Re: Section 4.55 (1A) modification to SSD 7424 (Smeaton Grange Waste Recycling and Transfer Facility)

This letter accompanies an application to modify the consent for SSD 7424 dated 22 December 2017 and is a Statement of Environmental Effects (SEE) for the application.

SSD 7424 is for a Waste Recycling and Transfer Facility (the facility) at Lot 319 DP 117230, also known as 52 Anderson Road, Smeaton Grange (the site), as shown in Figure 1.

drawing title  
GROUND FLOOR PLAN

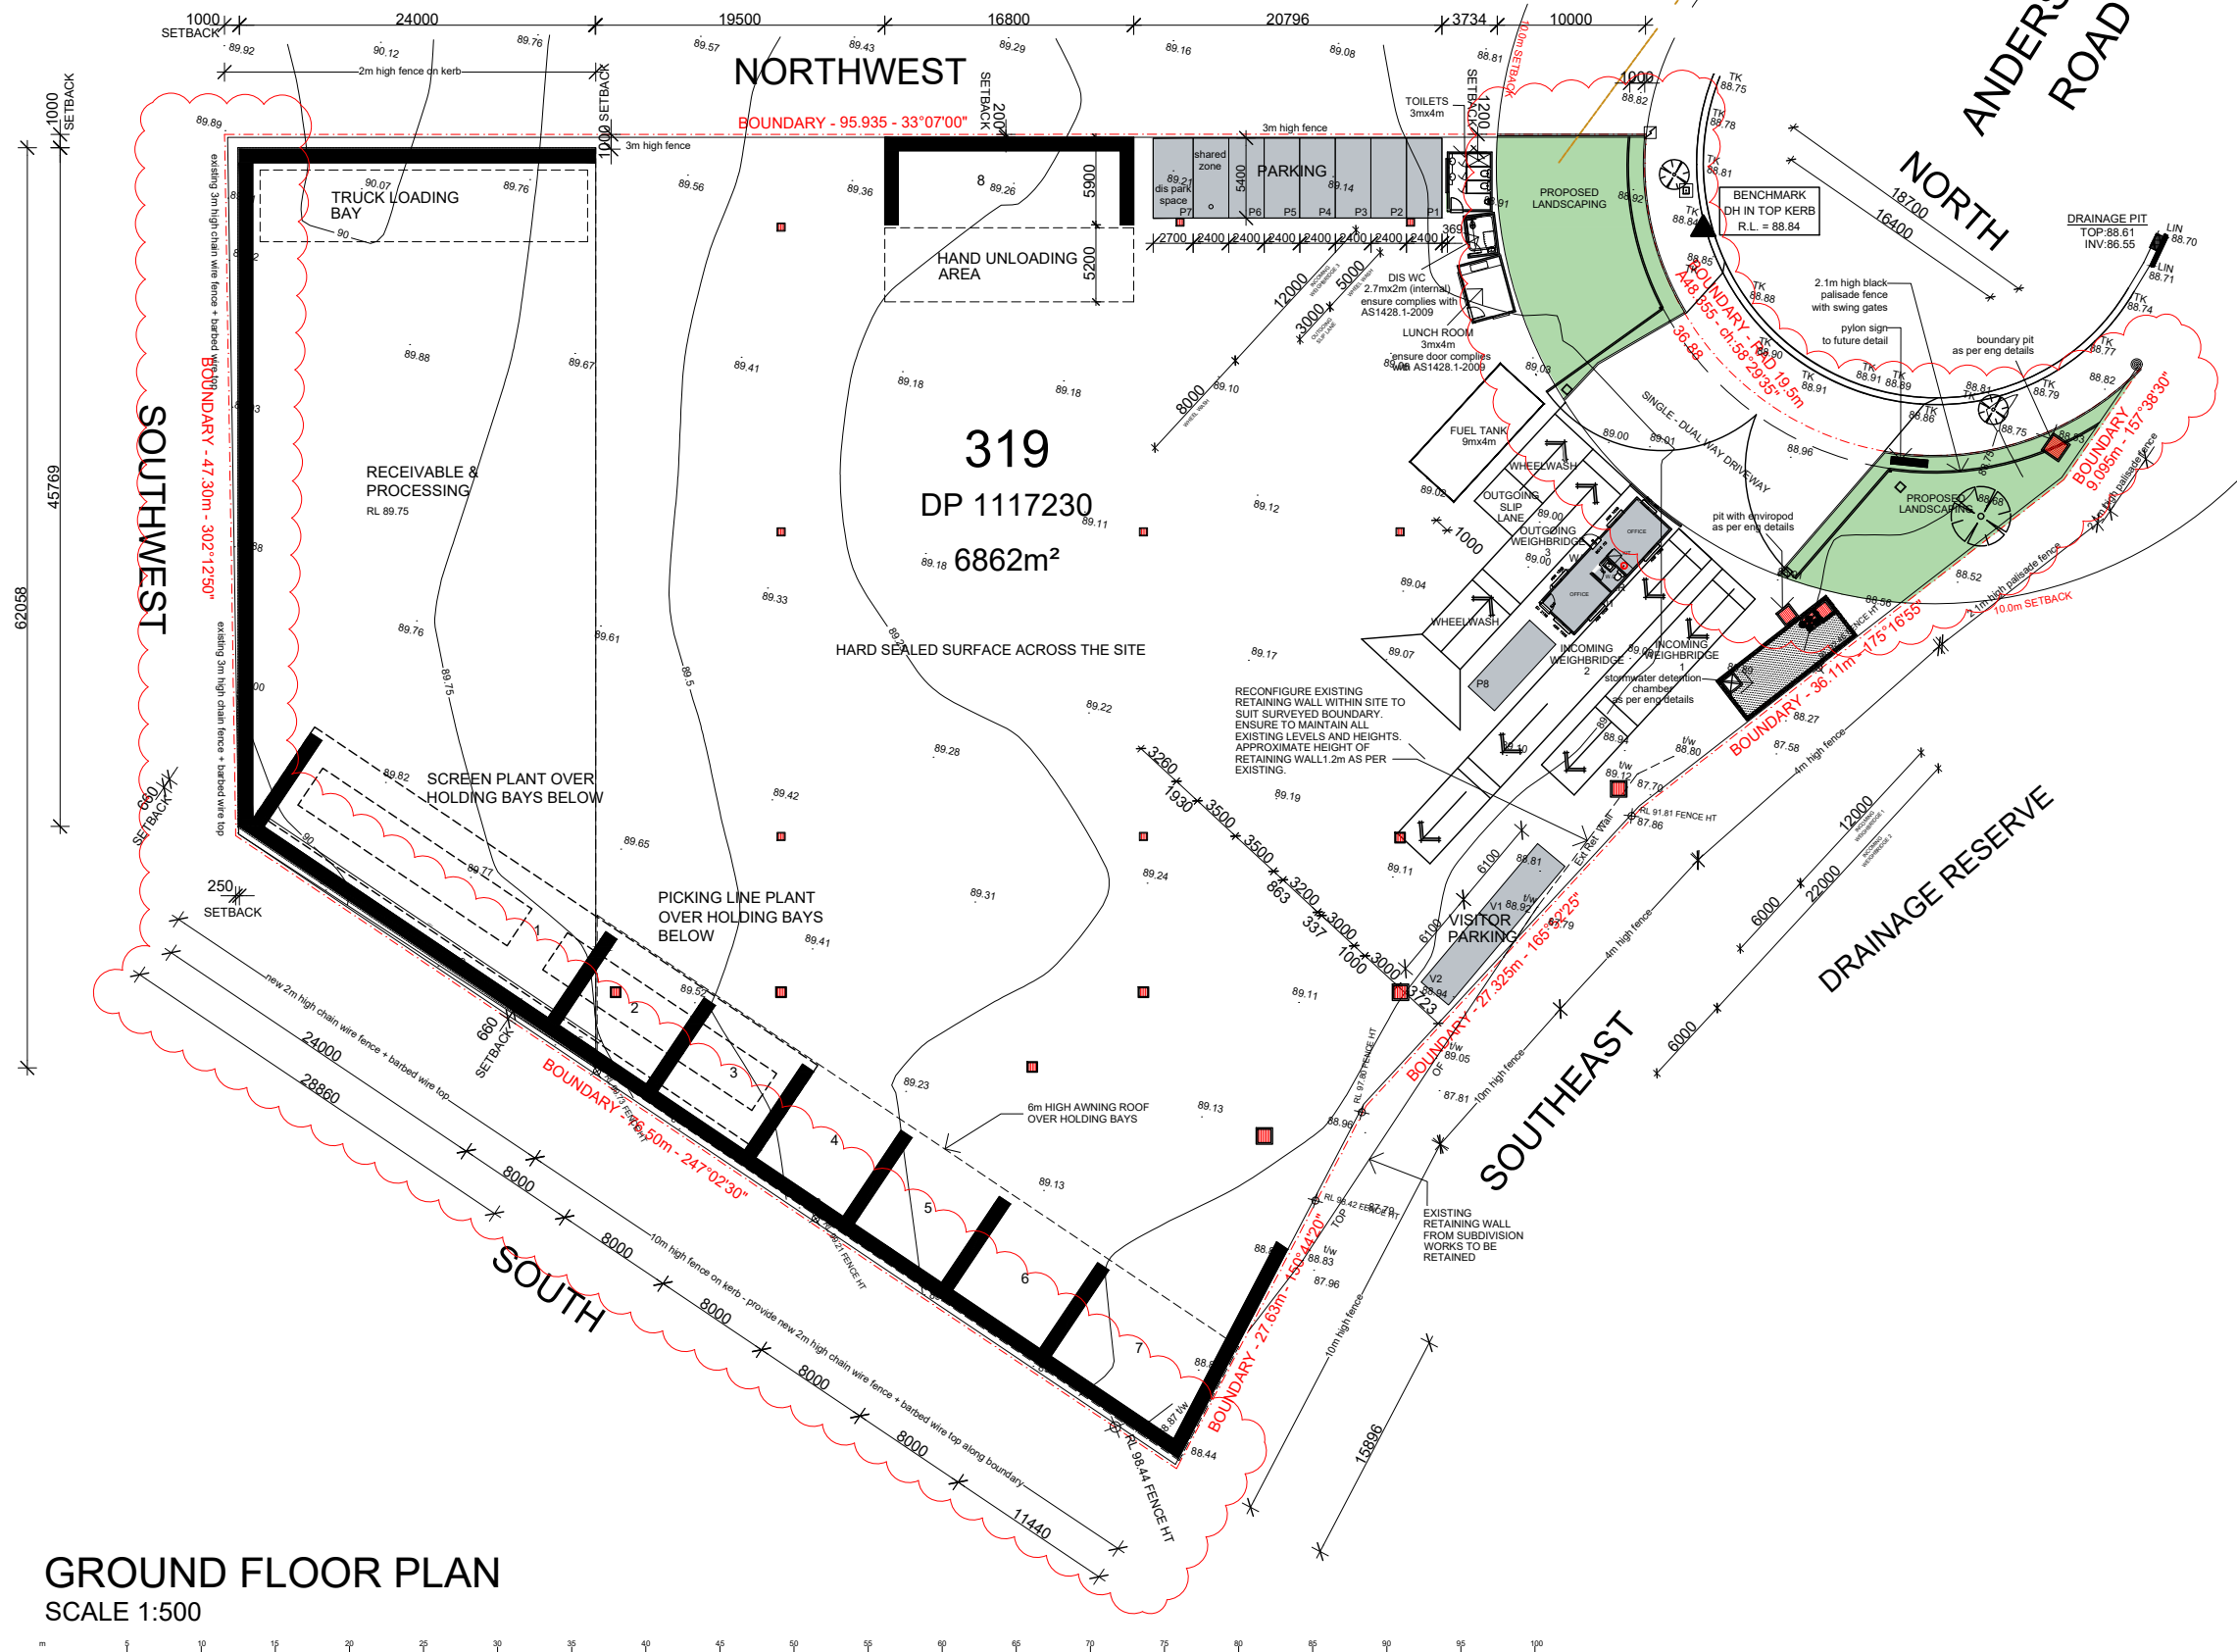
The proposed modification seeks to retain the style of the existing fencing between the site and the Coles site directly to the south-west. The existing plans show that the current 3 m wire security fence being replaced with a 2 m solid fence. Retention of the style of the existing chain wire fence will preserve the security of the Coles site, whilst minimising accessible surfaces for graffiti.

The proposed modification seeks to add a chain wire security fence on the southern boundary. While there is an existing palisade fence at the boundary, it has been determined that a chain wire security fence would be more appropriate as it would further minimise accessible surfaces for graffiti (ie the wide surfaces of the palisade fence and the rear cladding of the bay walls accessible by standing on top of the palisade fence). A security topping, ie a barbed wire topping (similar to the neighbouring Coles fencing), or looped security wire, would prevent access to the site, as well as deter potential vandals from standing atop the fence.

The proposed modification seeks to reduce the setback of the entrance fencing and gates from 10 m to 1 m. The material and size of the entrance fencing and gates, approved as a 2.1 m tall black palisade fence, will not change. The form of the gates will be changed from sliding gates to inward swinging gates. The 10 m landscape area is not proposed to be reduced.

The proposed modification would allow for a driveway wide enough to accommodate the swept paths as described above and shown in shown in RTS Appendix F. A comparison of the driveway configurations is at Figure 2.

FRONT FENCE DETAIL PLAN  
SCALE 1:200

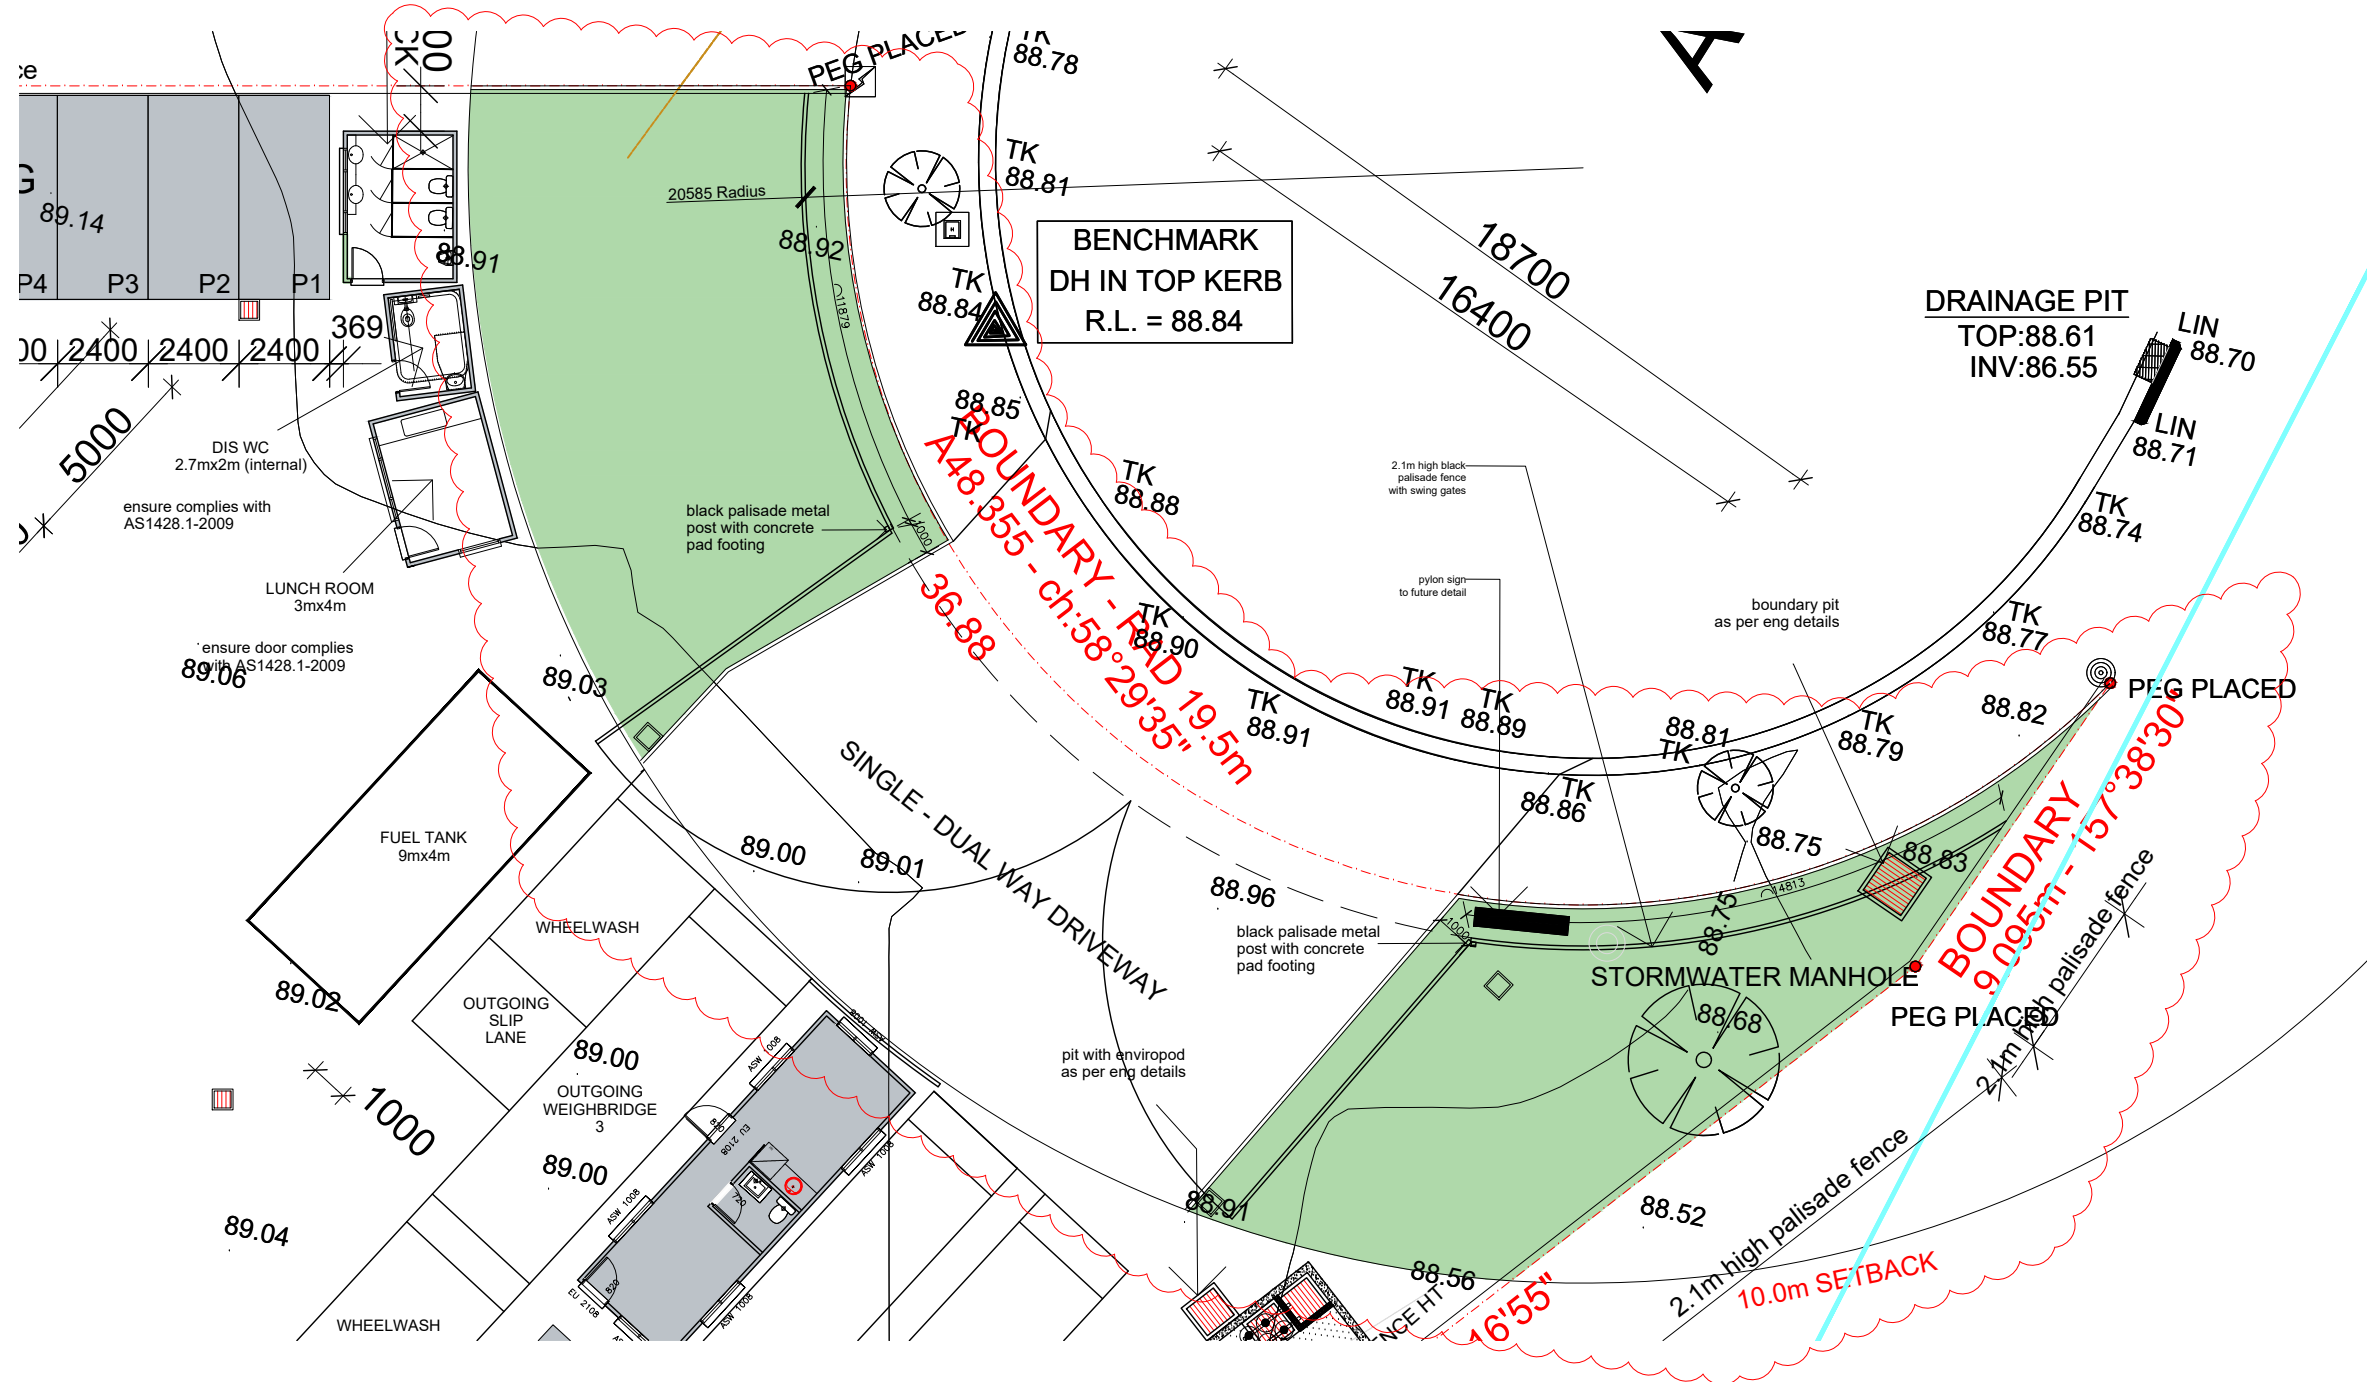
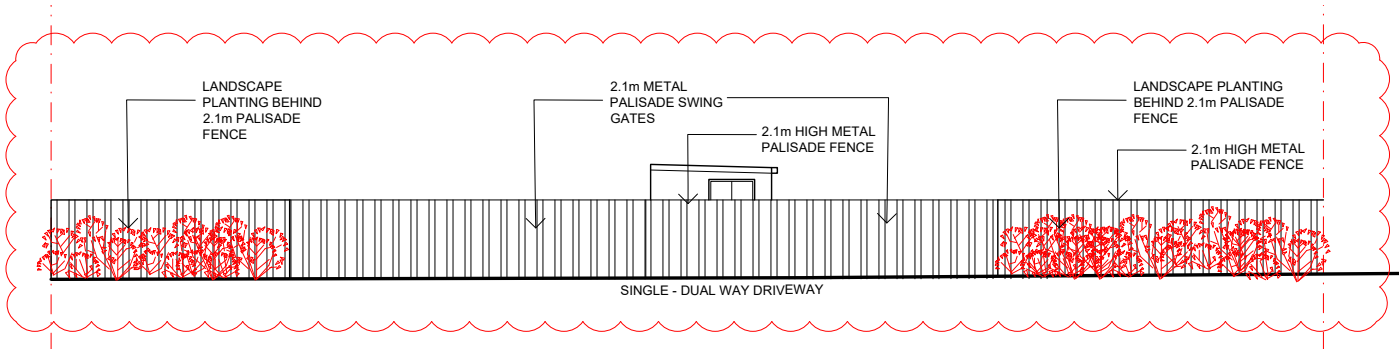
The reduced setback of the fence will also increase the security around the site. The current landscape design is fully accessible from the street, with obscured views to the landscaped areas. The fence would continue to allow for views into the landscaped areas during the day, while preventing direct access.
